## City of Albuquerque

RE: DRAINAGE PLAN FOR LEAVITT RESERVOIR II (L-9/D8) ENGINEER'S STAMP DATED  
OCTOBER 1, 1991 RECEIVED OCTOBER 16, 1991

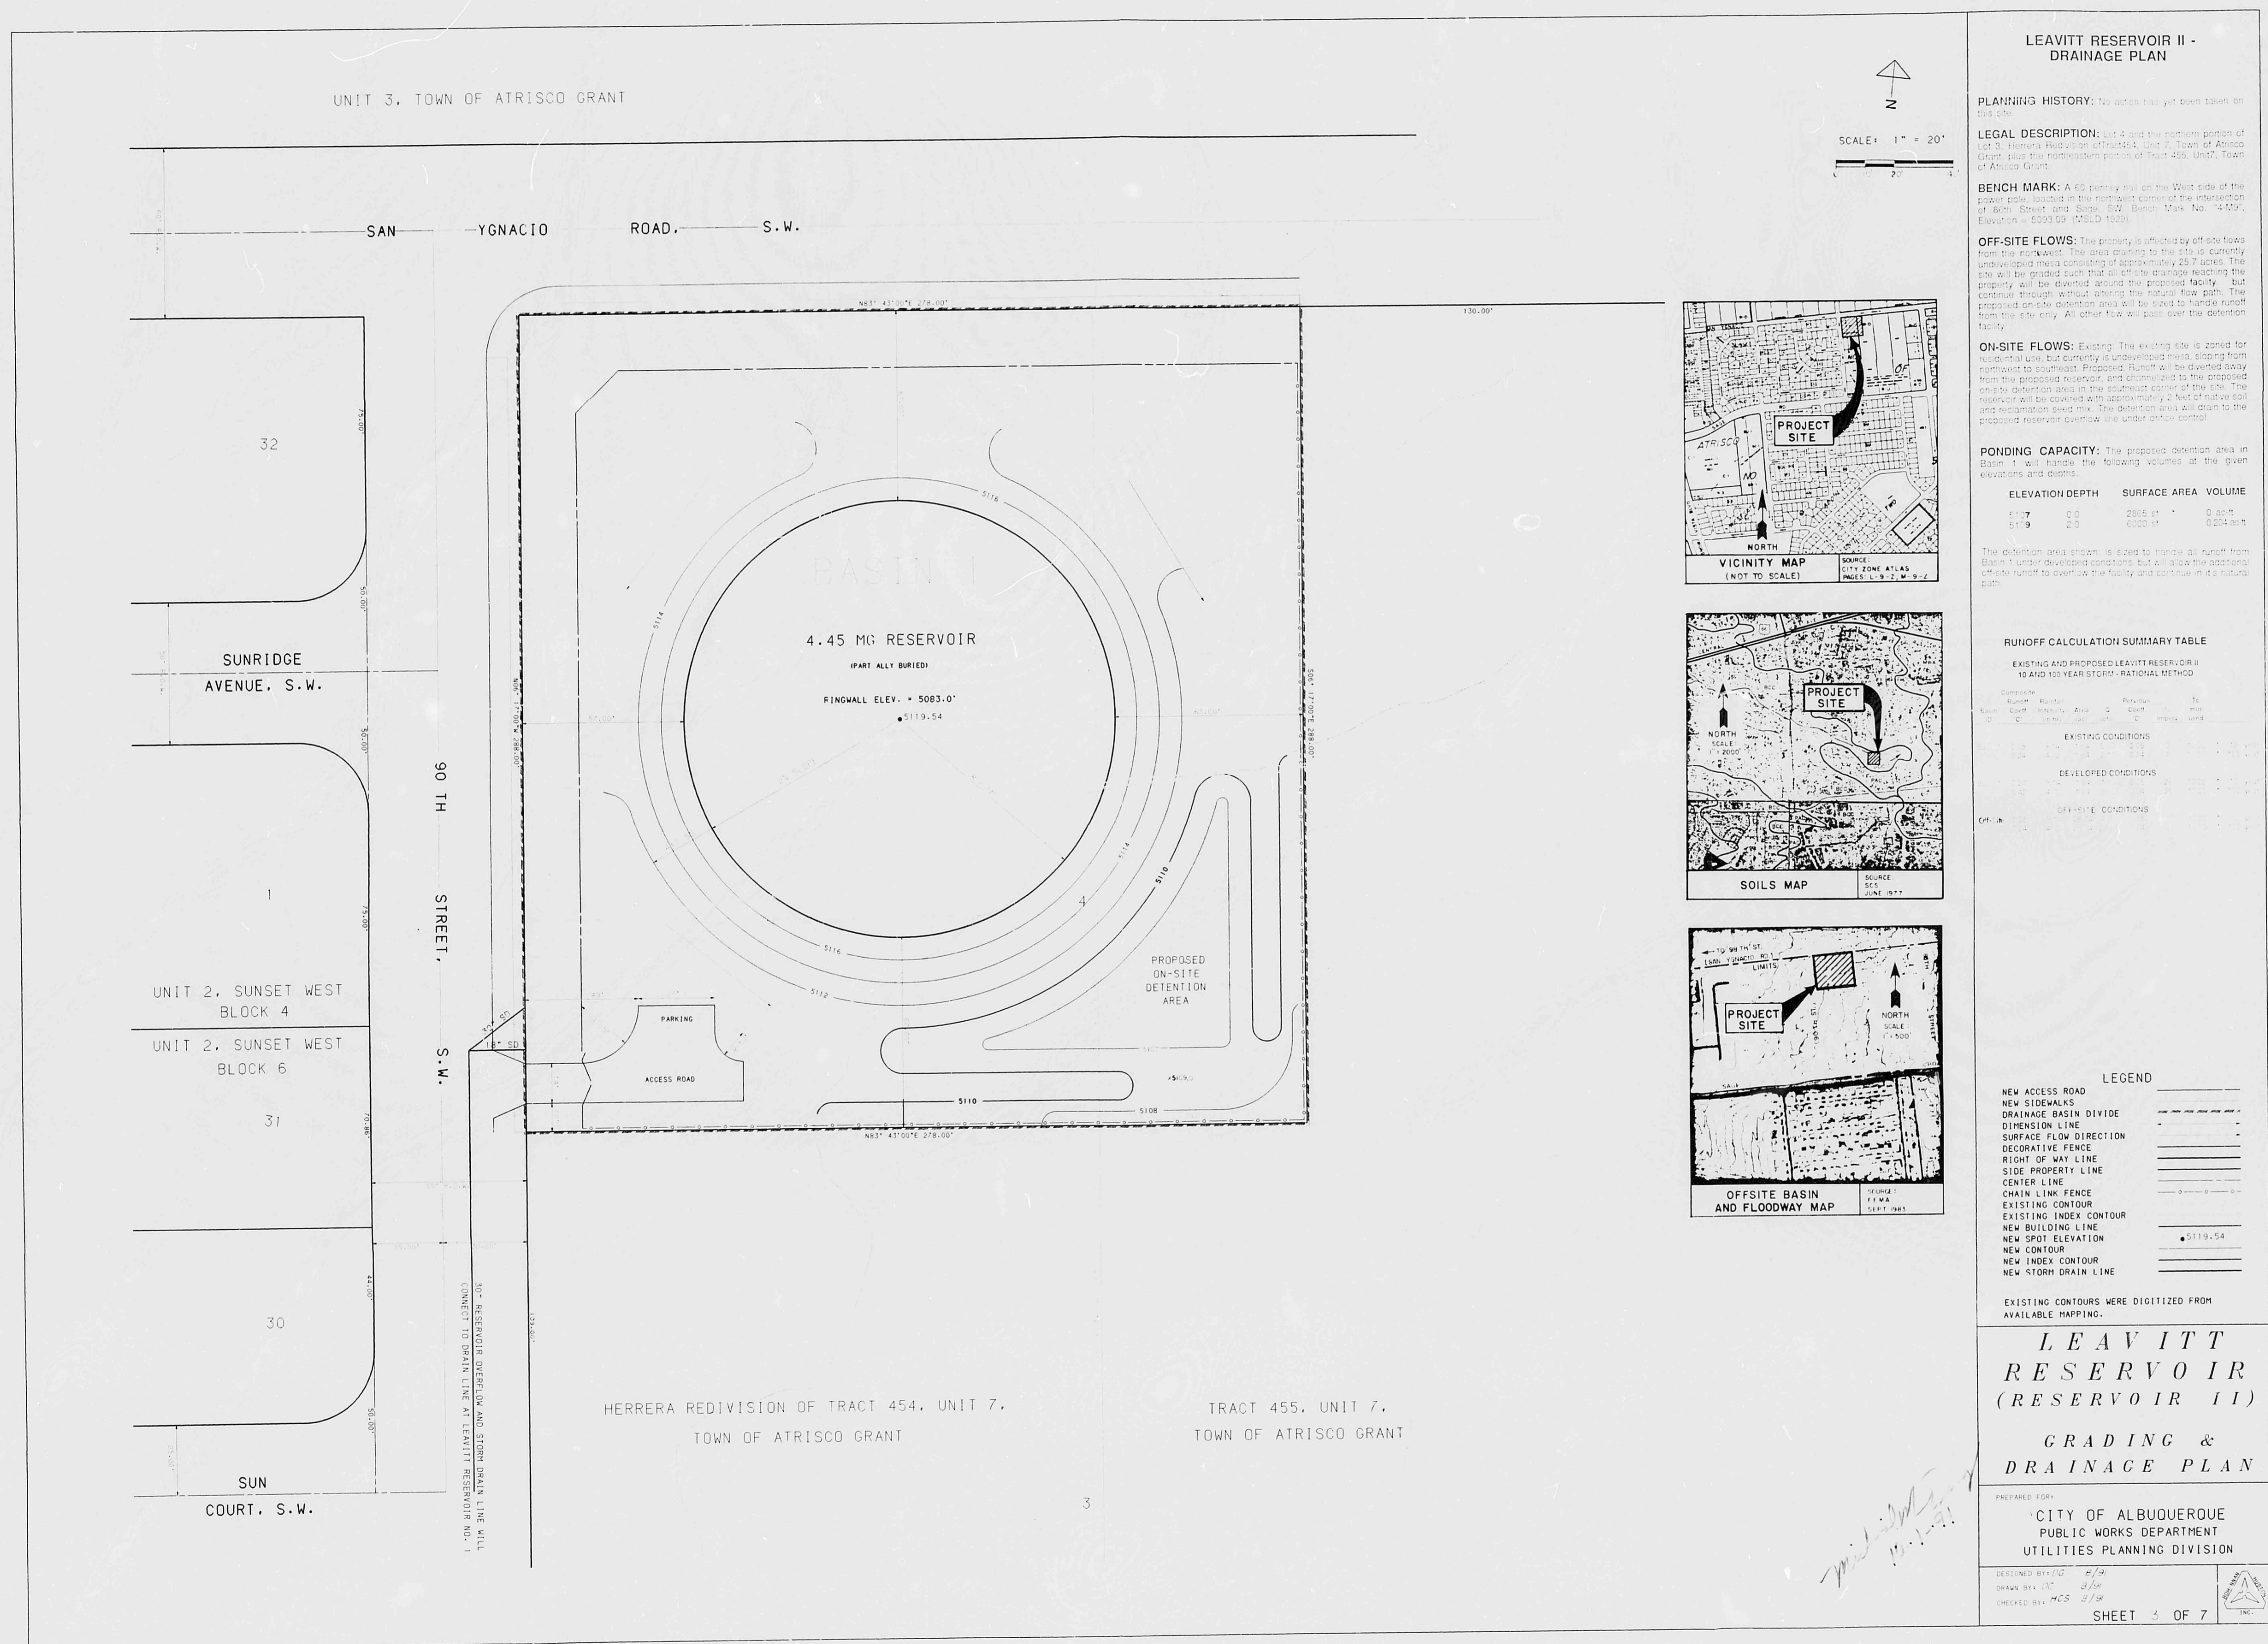
1. You indicate a 30" S.D. & 18 S.D. adjacent to the west property  
line. Where do they go from there?
